Subject: RE: R/202/17/TEL - Prior Notification for installation of a 15m monopole supporting 3No. antennas, 1No. equipment cabinet and ancillary development. Remove existing 2No. cabinets & 3No. antennas Claigmar Road, Rustington

Subject: R/202/17/TEL - Prior Notification for installation of a 15m monopole supporting 3No. antennas, 1No. equipment cabinet and ancillary development. Remove existing 2No. cabinets & 3No. antennas Clagmar Road, Rustington

I have been discussing your proposal with the parish council and would appreciate clarification as to what equipment is to be removed. Whilst the description of the application relates to removal of 2 cabinets and 3 antenna (and makes no reference to removal of a mast) the submitted site plan and elevations only outline one cabinet to be de-commissioned not 2 and the plans make reference to decommissioning of a pole and not removal of antenna.

Drawing Title: PROPOSED SITE ELEVATION

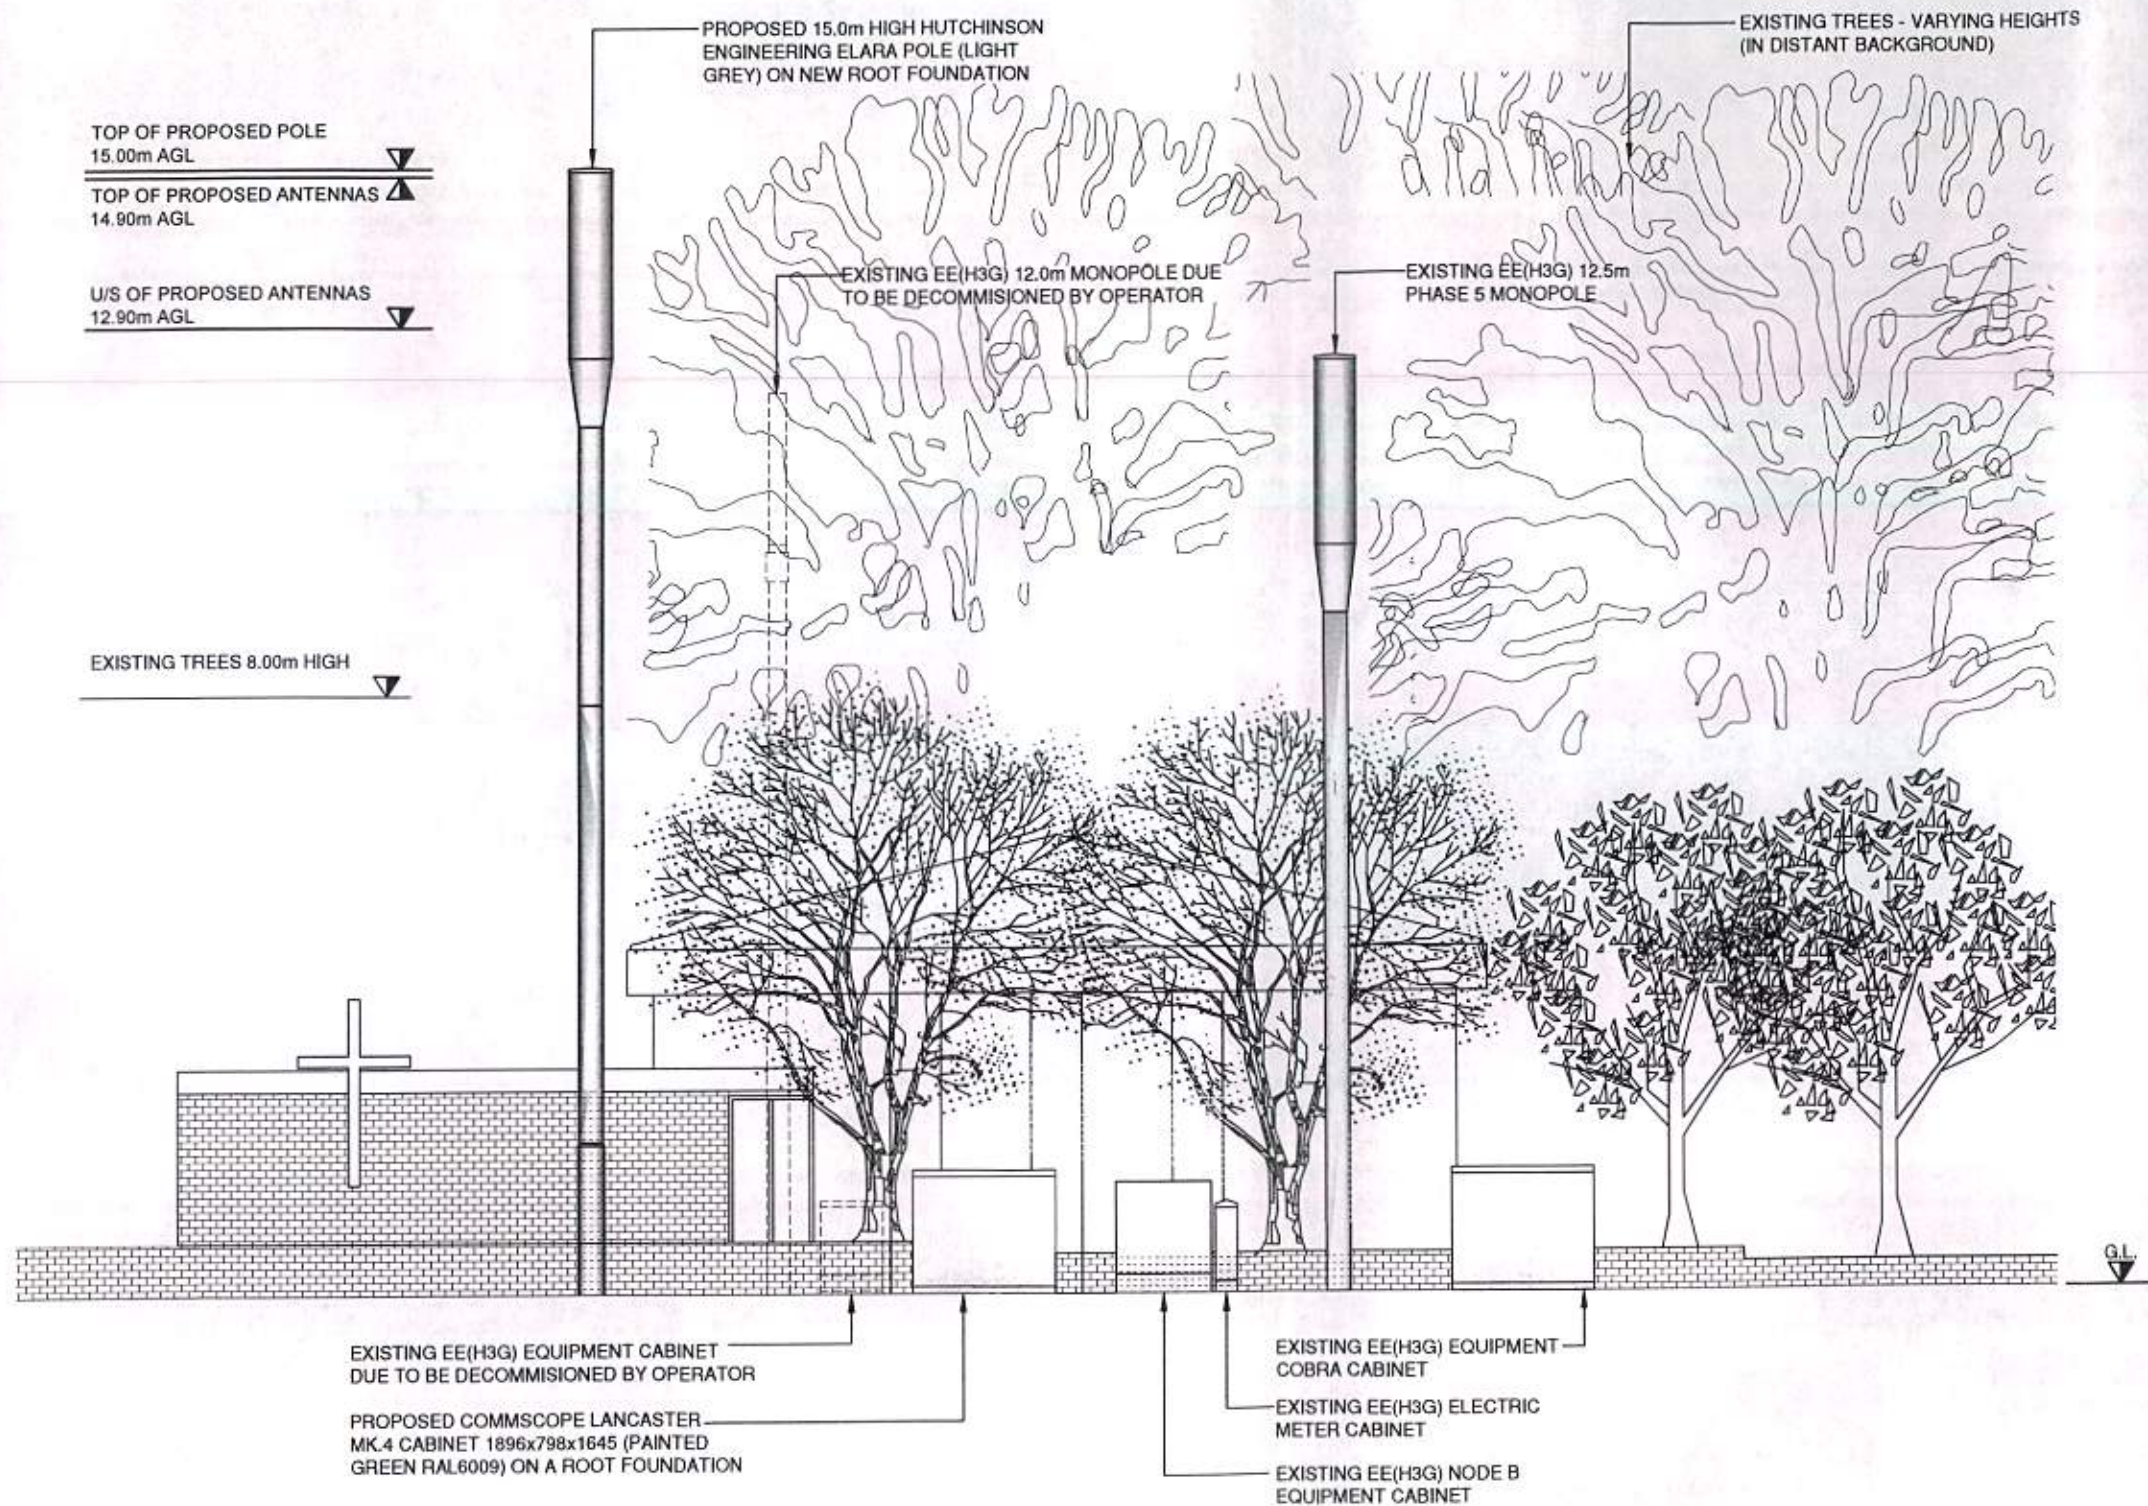
I therefore request that revised proposed site and elevation plans are submitted clearly showing the cabinets, antenna, mast that are to be removed .

The drawings provided in the application show a pole and cabinet which we understand are to be removed as part of a recent upgrade to the equipment adjacent to the application site by EE.
